**OXFORDSHIRE COUNTY COUNCIL’S RESPONSE TO CONSULTATION
ON THE FOLLOWING DEVELOPMENT PROPOSAL**

Application no: 22/01611/OUT

Proposal: Outline planning application for up to 118 no dwellings (all matters reserved except for access) with vehicular access from Oxford Road

Location: Stratfield Farm 374 Oxford Road Kidlington OX5 1DL

Footway Connection – Croxford Gardens
MAC drawing no. 122-TA06

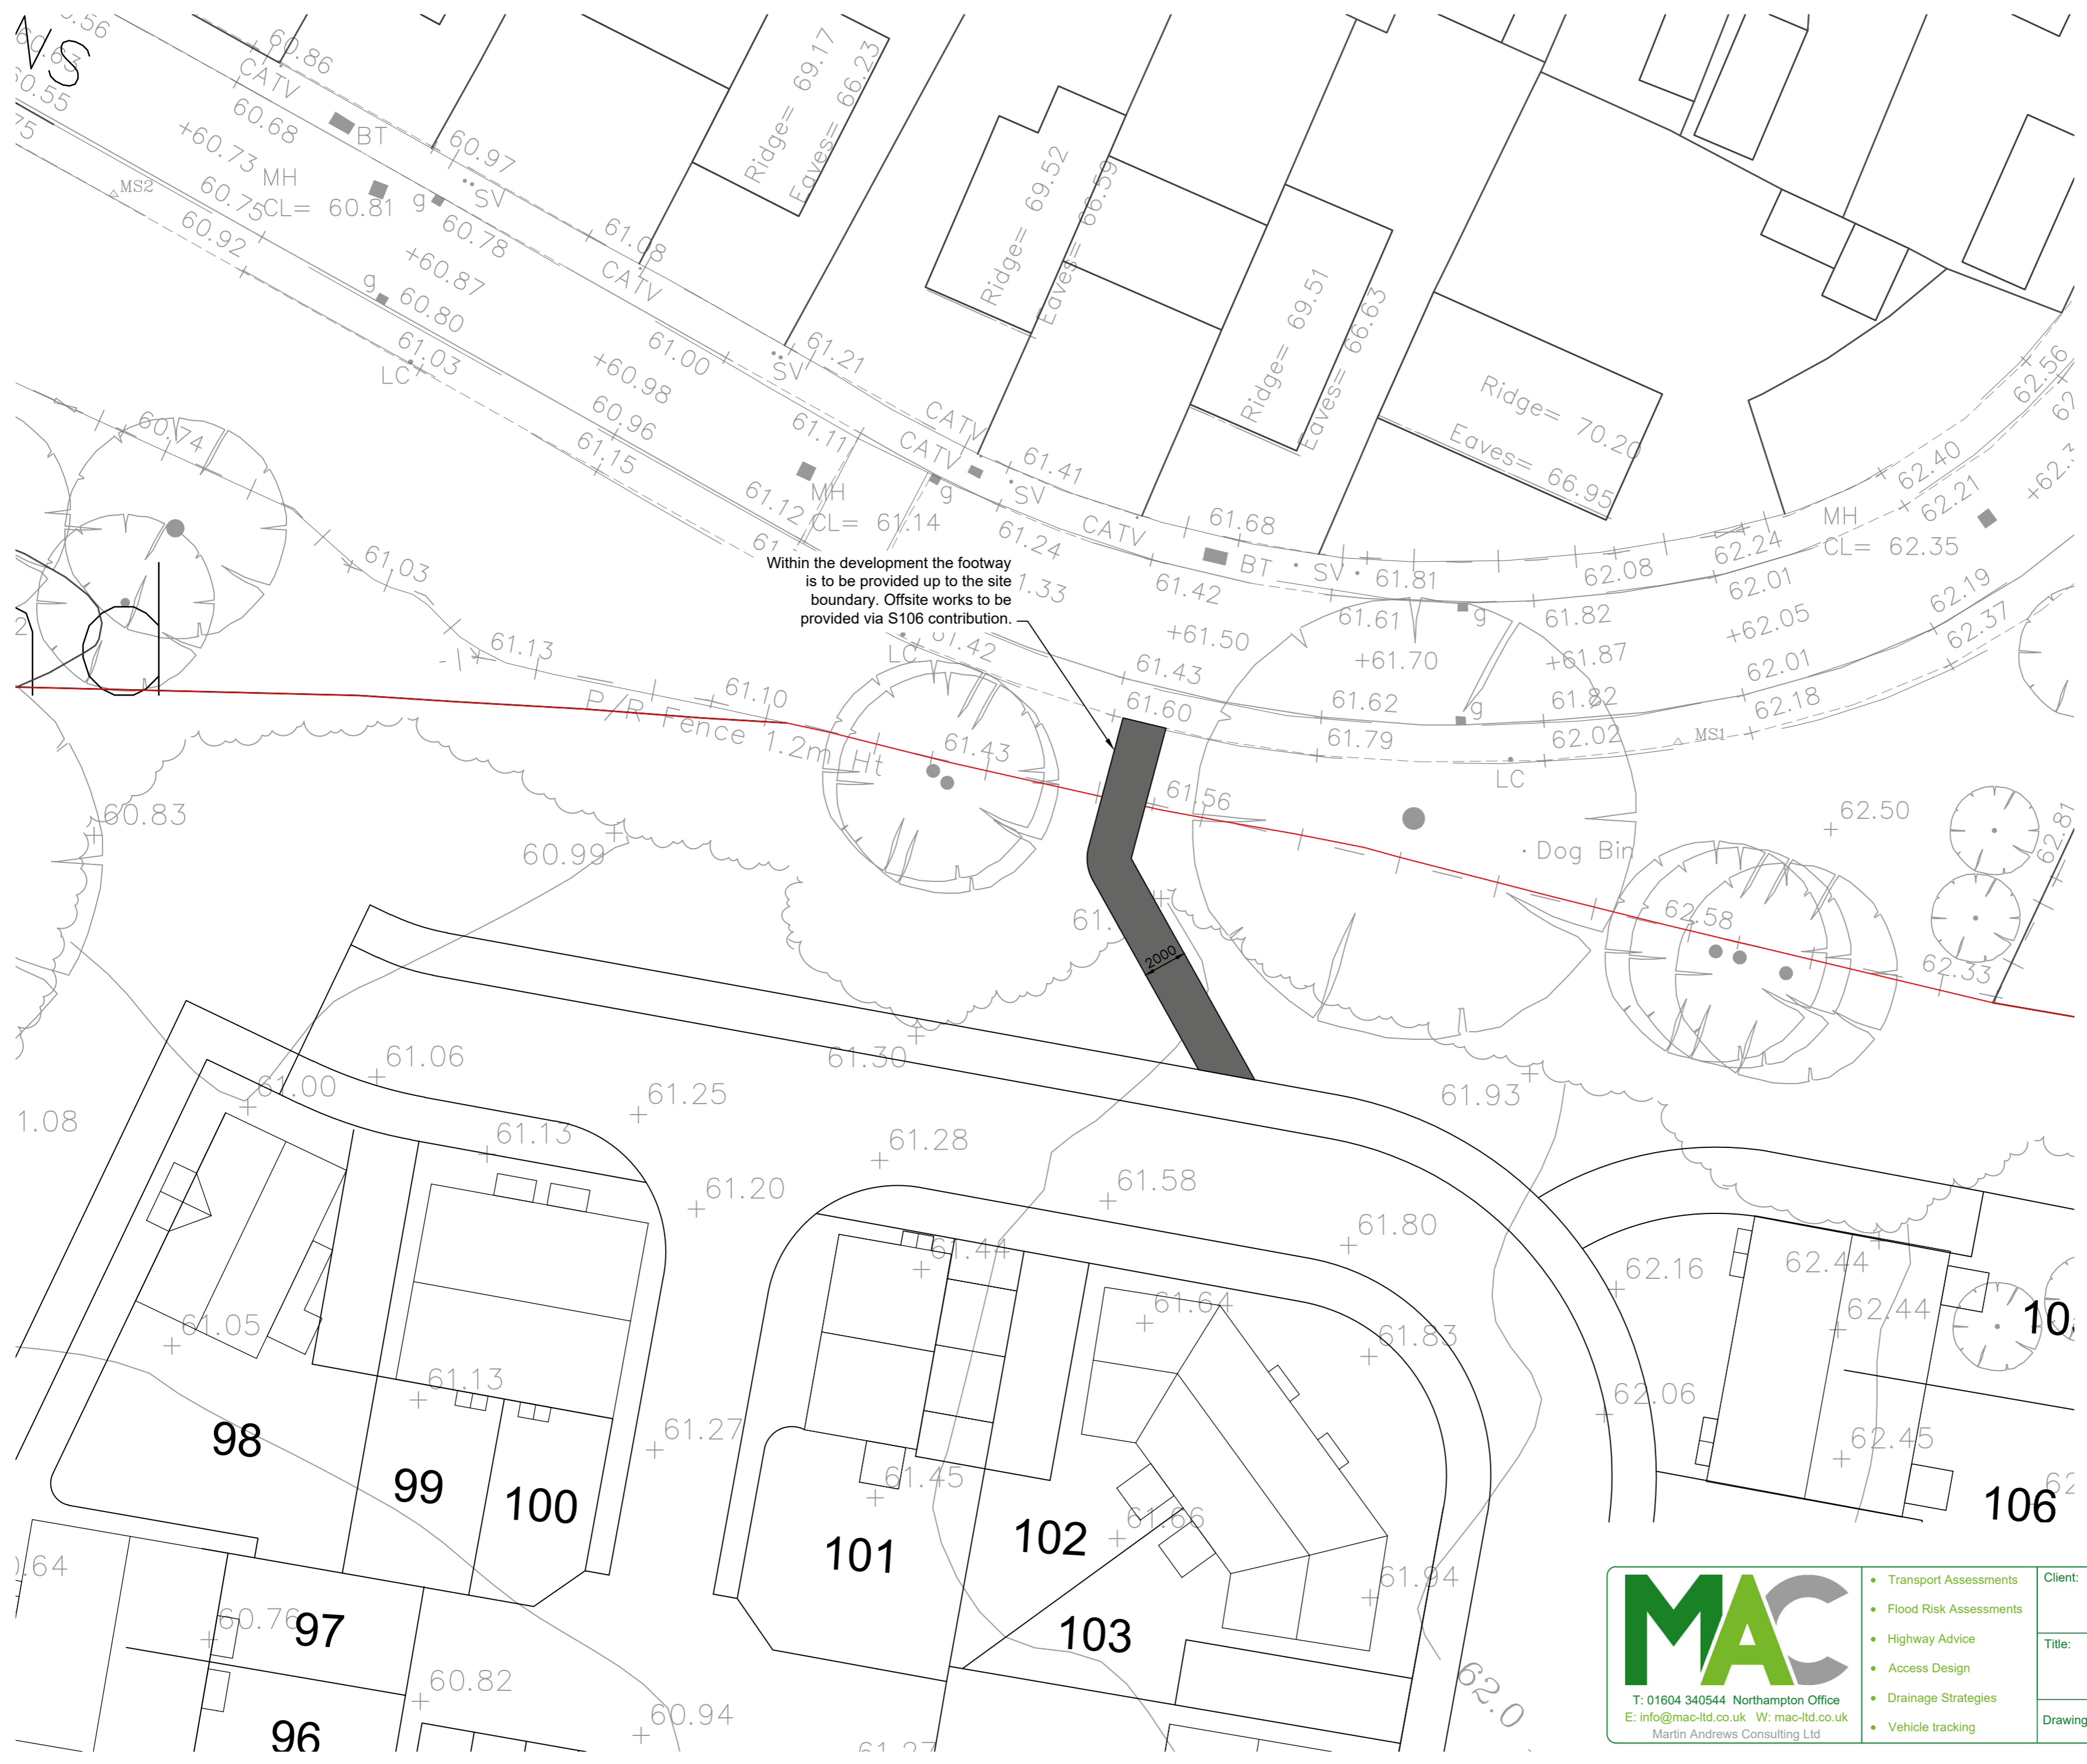
It is not apparent whether the application intends to provide access to Croxford Gardens to the north of the site. The illustrative masterplan appears to show routes towards Croxford Gardens but the connection point has not been shown - it is obscured by tree canopies. I would like to see a clear access and connectivity strategy with details of each access point to confidently consider the site's permeability.
